MEMORANDUM

TO: Jean Fraser, Planner
FROM: Ashley Auger, E.I.T. & David Senus, P.E.
DATE: July 21, 2011
RE: McFarland Spring Corporation – 280 Warren Avenue

Woodard & Curran has reviewed the Final Level II Site Plan Application for the McFarland Spring Corporation project located at 280 Warren Avenue in Portland, Maine. The project proposes to construct a 1,400 Square Foot (SF) building addition to an existing 8,400 SF industrial building. Associated site improvements will include additional paved surface.

PROJECT	280 WARREN AVE PORTLAND, MAINE
SHEET TITLE	DETAILS
CLIENT	MCFARLAND SPRING CORP.

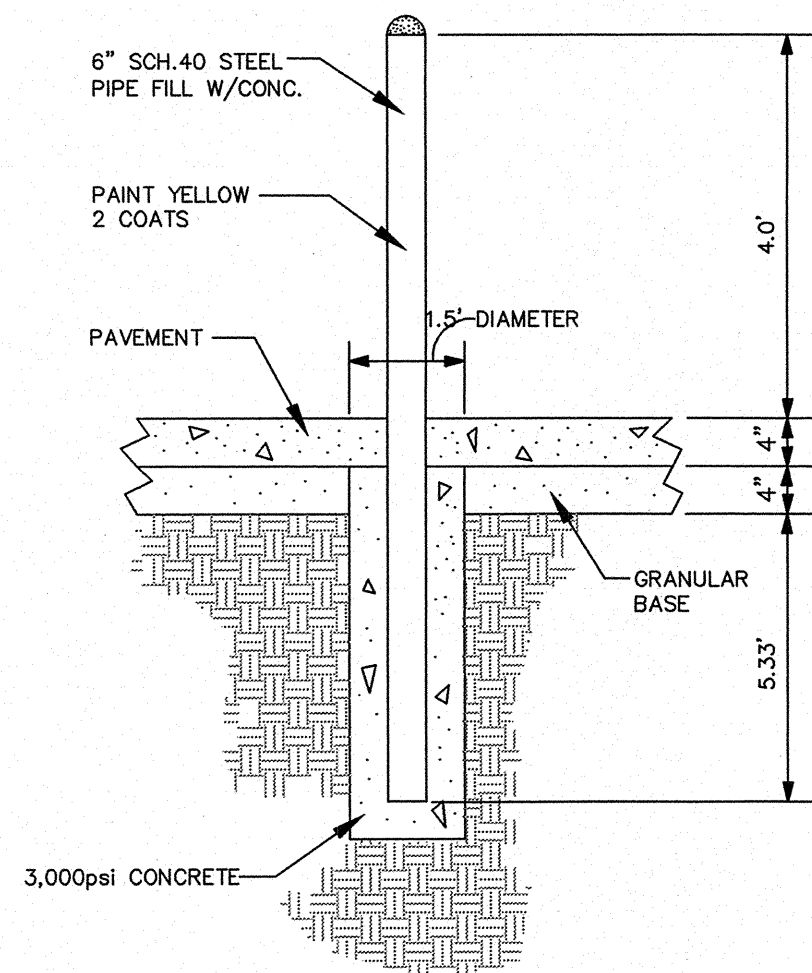
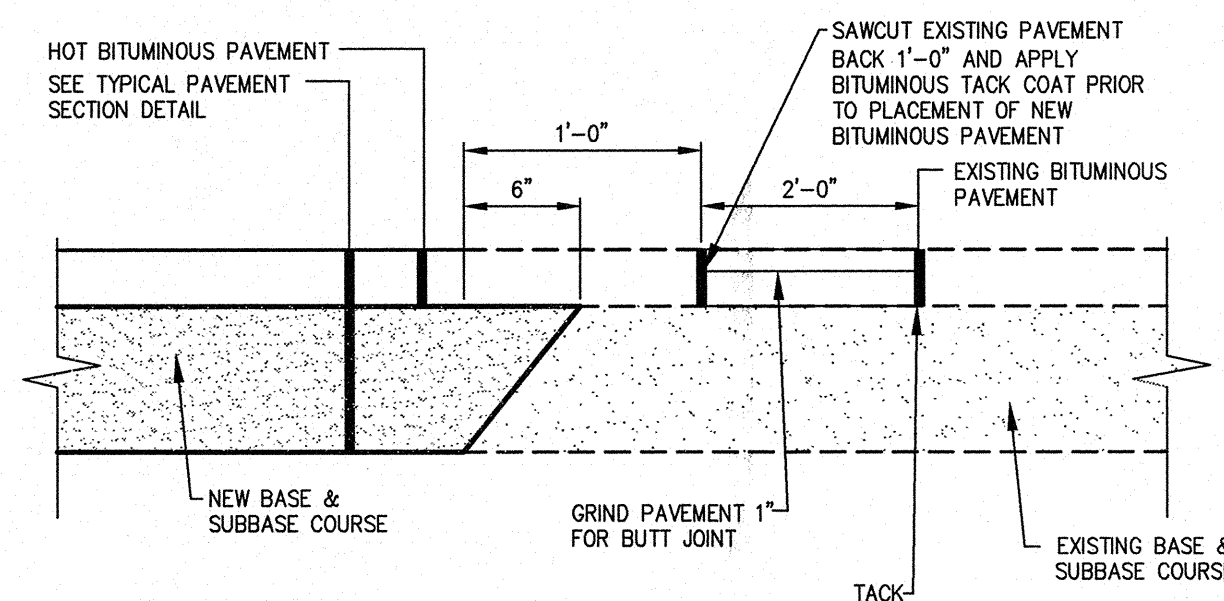
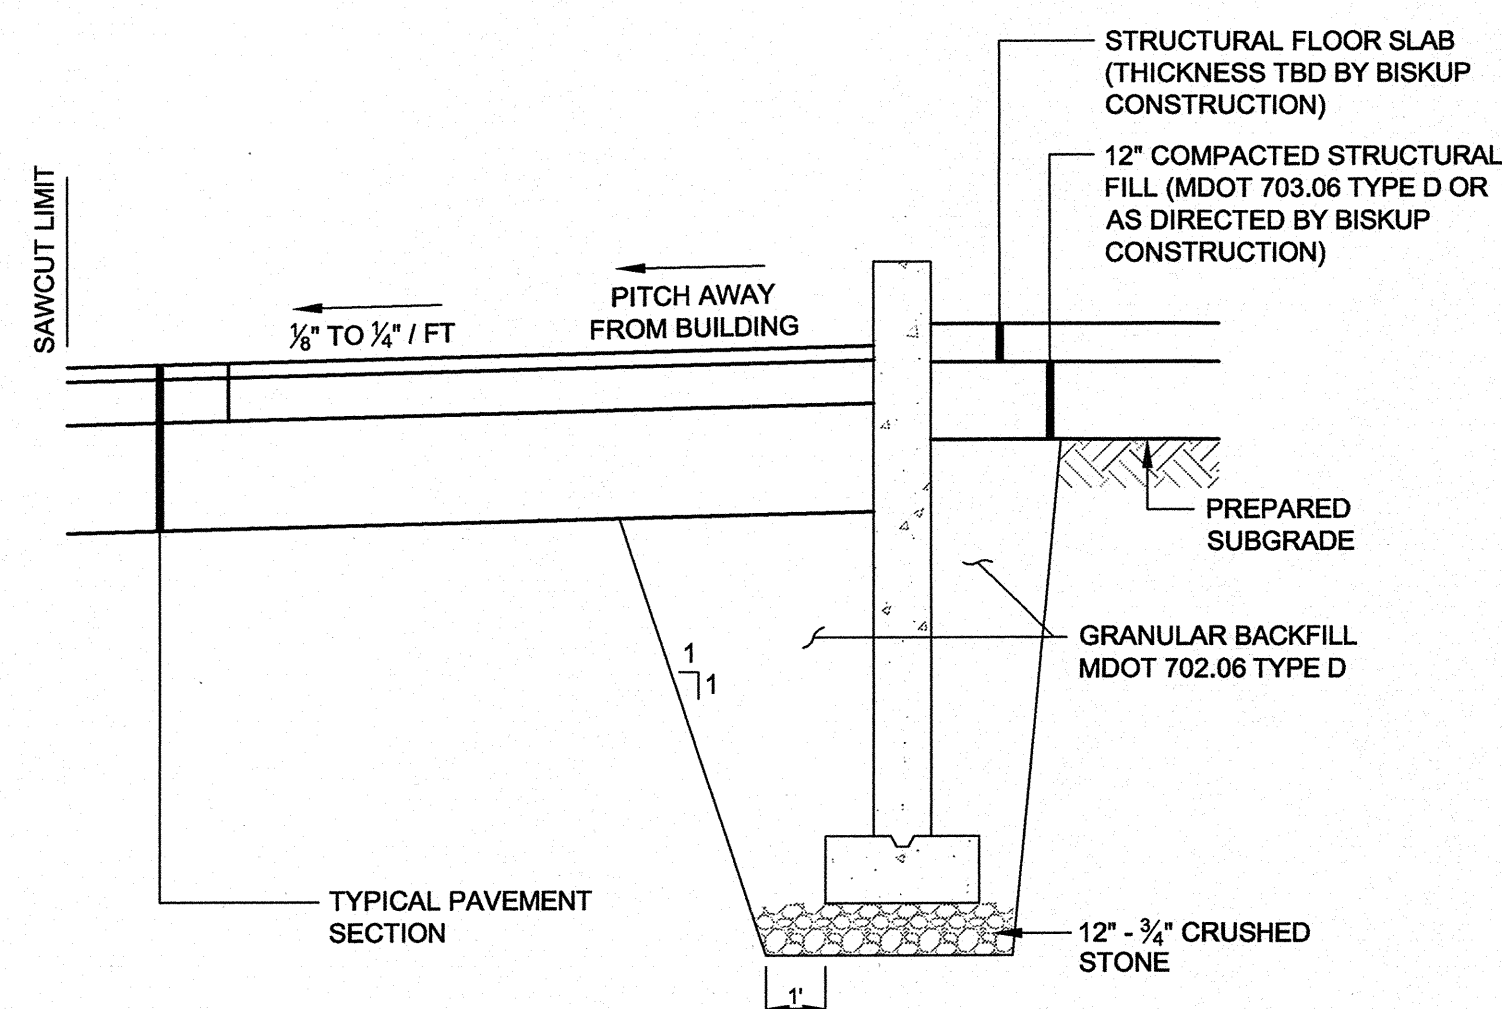
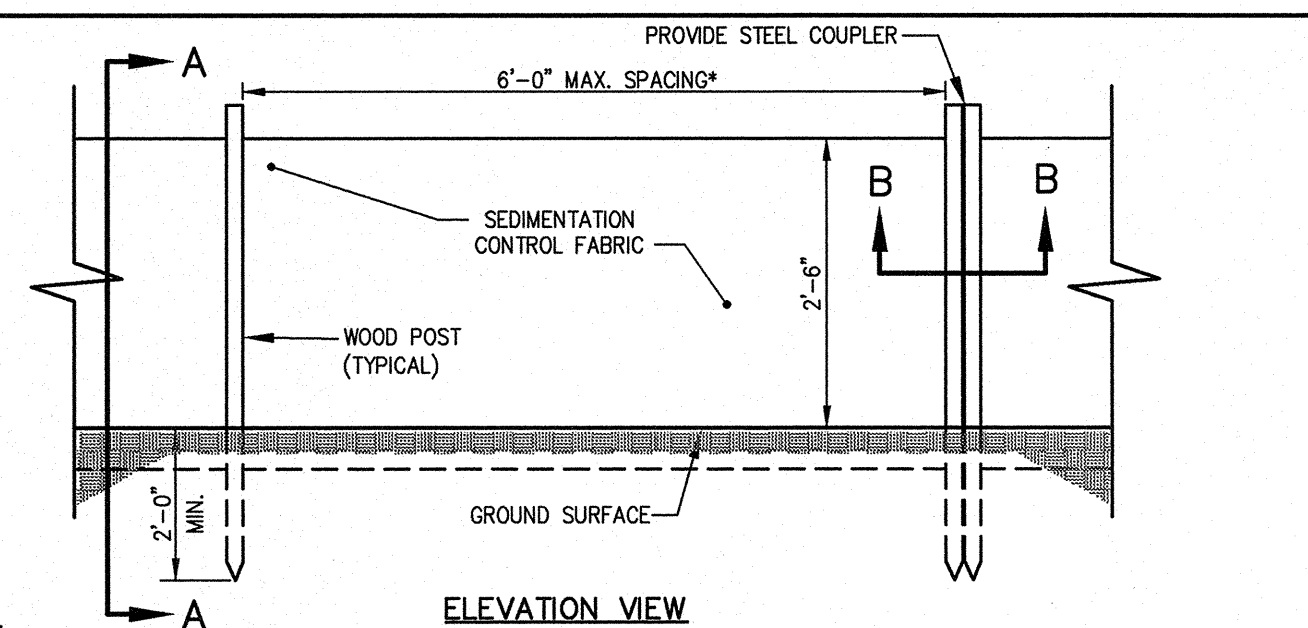
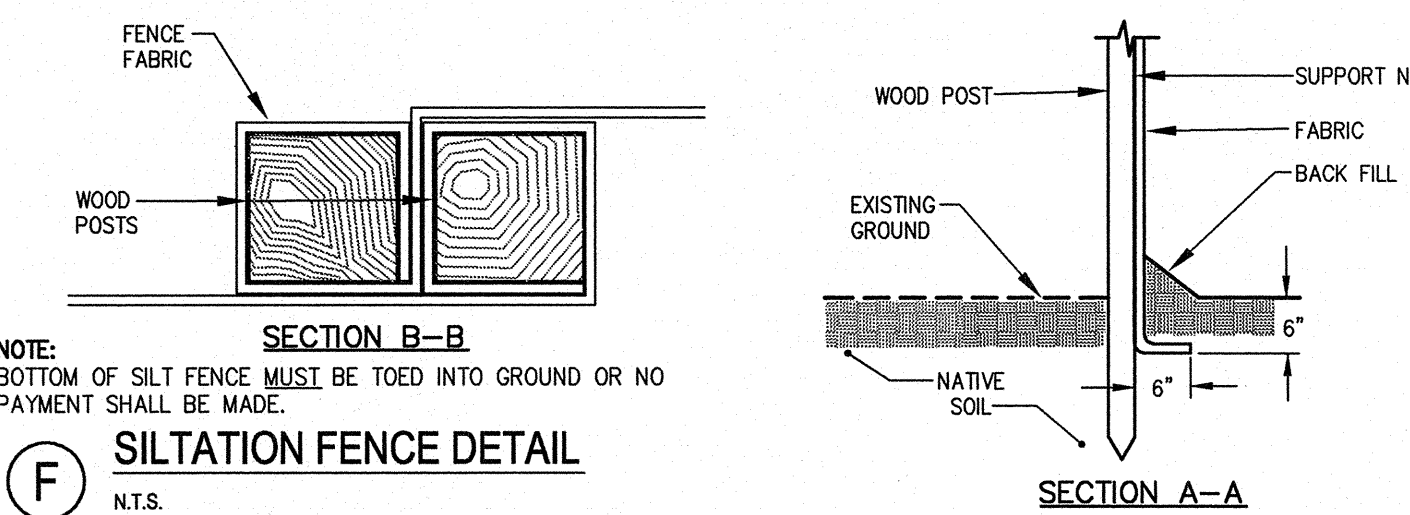
- Please provide a detail for the proposed stabilized construction exit per B-4 of the MaineDEP Erosion and Sediment Control Best Management Practices Manual.
